Ribble Valley Borough Council  
Housing & Development Control

App. no: **3/2023/0687**

Address: **Healings Farm West Bradford Road Waddington BB7 3JE**

Proposal: **Prior notification for the demolition of existing workshop building and replacement with one new two-storey dwelling with basement, including landscaped gardens, access and parking.**

Site plan as proposed 1:500 @ A3

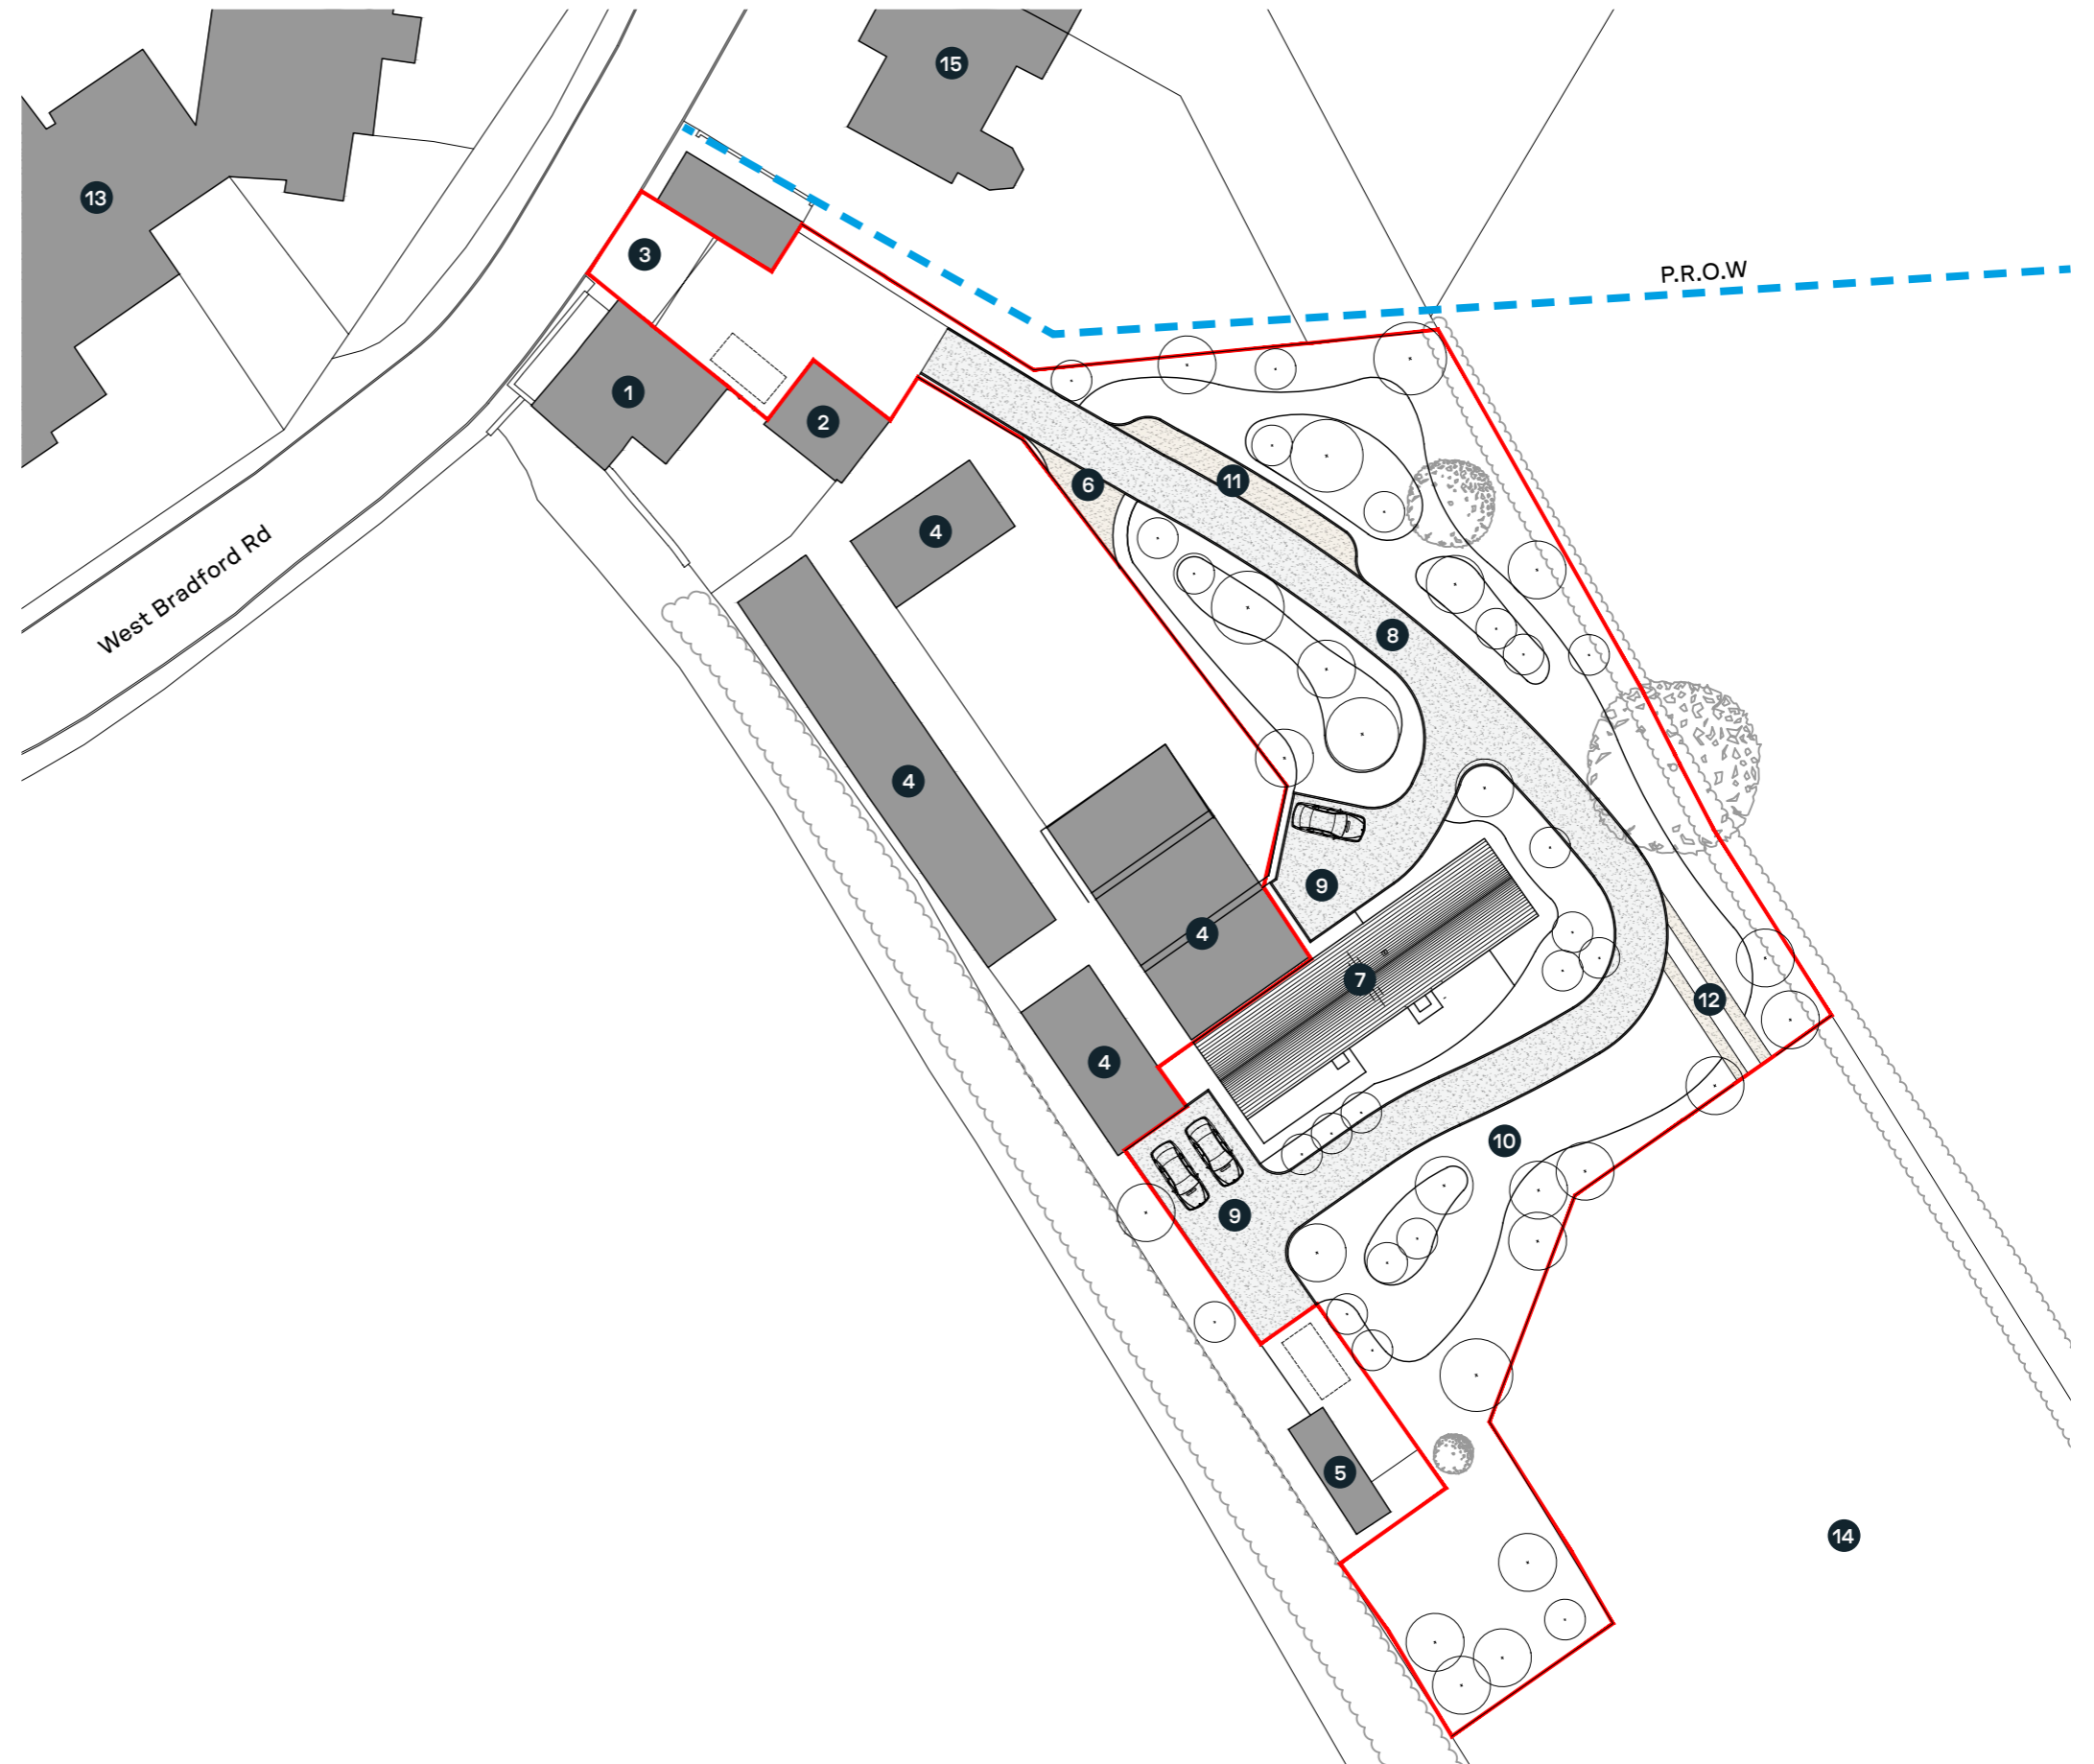
The LHA have reviewed Rural Solutions drawing titled "Site Plan As Proposed" and are aware that the existing access will remain unaltered as part of the application. Given that the existing use of the workshop generated trips in its own right and are likely to be similar to the number of trips which will be generated to the proposed dwelling, the LHA have no further comments to make regarding the site access with the proposal not being seen as an intensification of use.

The LHA have reviewed Rural Solutions drawing titled "Site Plan As Proposed" and are aware that 2 car parking spaces will be provided for the 4 bed dwelling. This does not comply with the LHAs parking guidance as defined in the Joint Lancashire Structure Plan, which requires the dwelling to provide 3 car parking spaces.

However, the LHA will accept the shortfall in parking for the proposed dwelling with the shortfall not having an impact on the adopted highway given that the site is located a significant distance away.

Furthermore, the LHA have reviewed Rural Solutions drawing titled "Site Plan As Proposed" and are aware that the proposal is aiming to formalise an access track which will serve the site. The proposed access track which connects to the site access and serves the agricultural field, two dwellings (including the one proposed) and a number of buildings which are used for light industrial, will be 3.5m wide which complies with the LHAs guidance. The LHA also welcome the introduction of a passing place along the track.

2. No part of the development hereby permitted shall be occupied until such time as the access and access track arrangements shown on Rural Solutions drawing titled "Site Plan As Proposed" have been implemented in full.

3. The development hereby permitted shall not be occupied until such time as the parking and turning facilities have been implemented in accordance with Rural Solutions drawing titled "Site Plan As Proposed". Thereafter the onsite parking provision shall be so maintained in perpetuity.
